A: BASNER AWAKENING METRIC

At the noise issue specific hearing, the writer (on behalf of No Night Flights) and Thanet District Council questioned the applicant's reliance on research by Dr Basner *et al* regarding night time awakenings.

B: NOISE MONITORS – FRUIT FROM THE POISONED TREE?

Figure 12.9
Aircraft noise - night-time L_{ASmax}
contours - year of forecast maximum
capacity

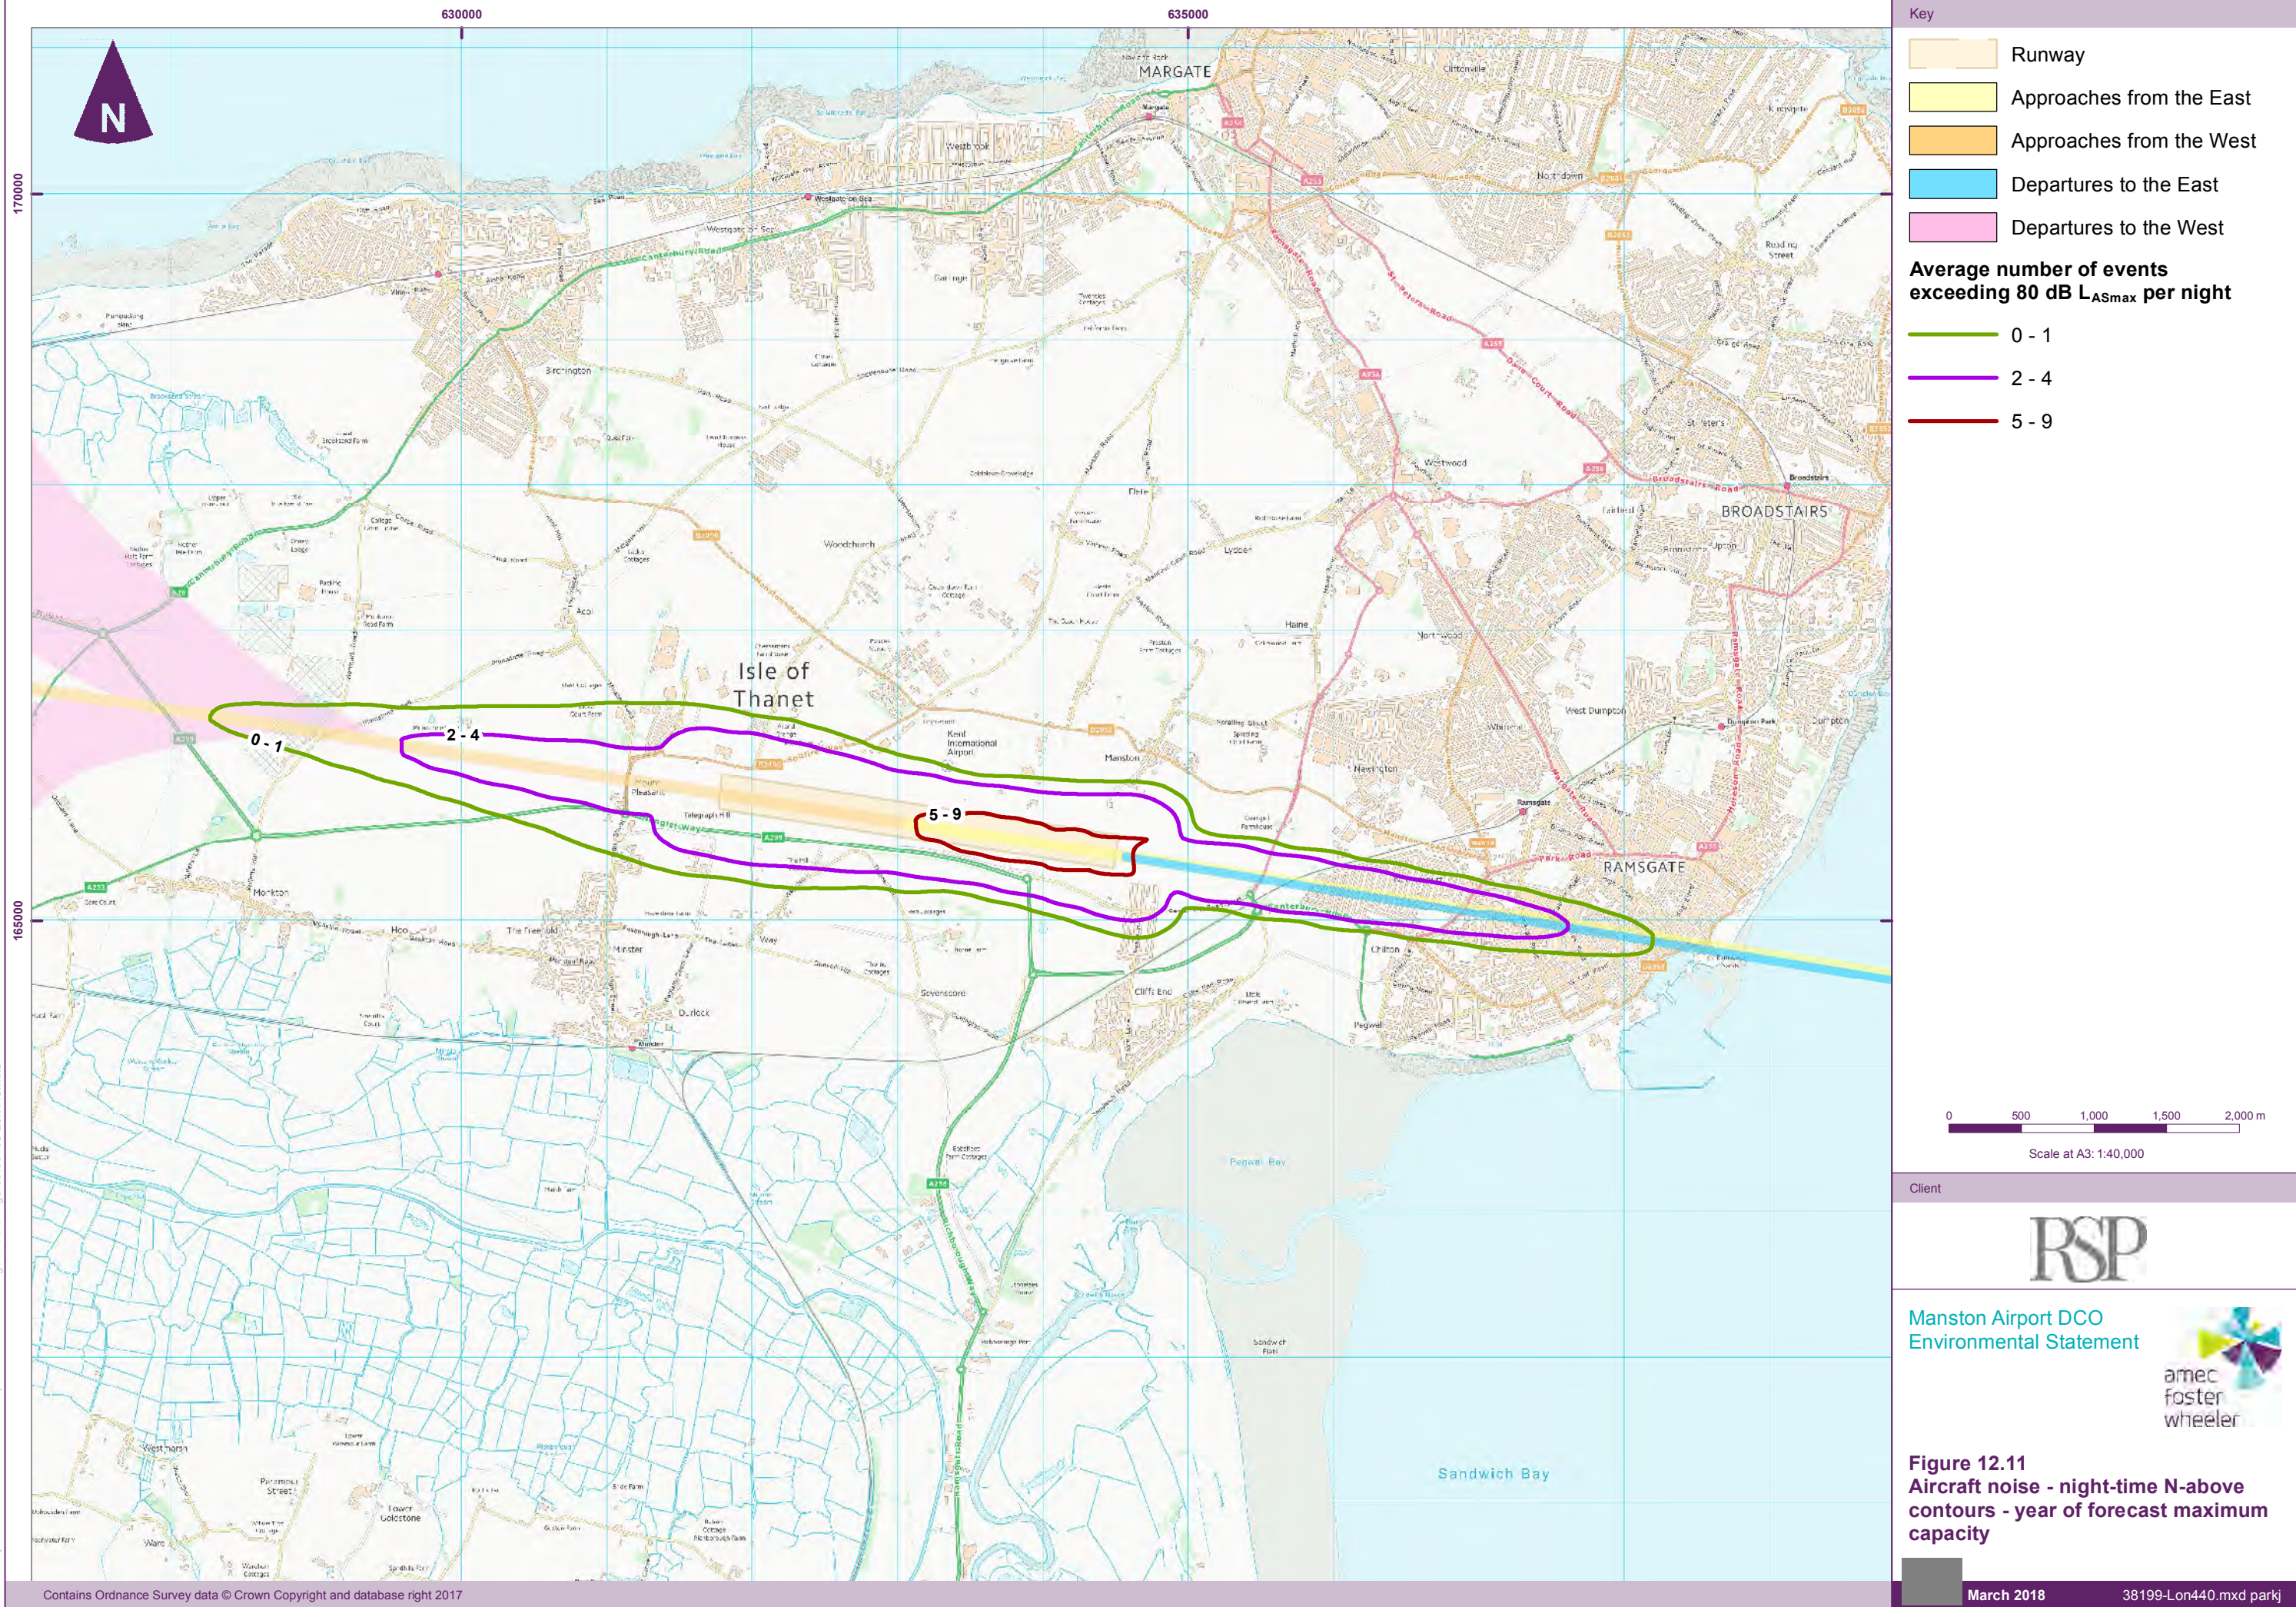
2. Why should we accept RSP's noise contouring, based on theory, when we have historical data and independent reports showing that 747-400s produce more noise and over a wider area?

5. What sleep disturbance – and for how many people - would the applicant predict from a maximum SPL of 95dB and the window open (worst case scenario) and how far would this be mitigated by his Noise Mitigation Plan?
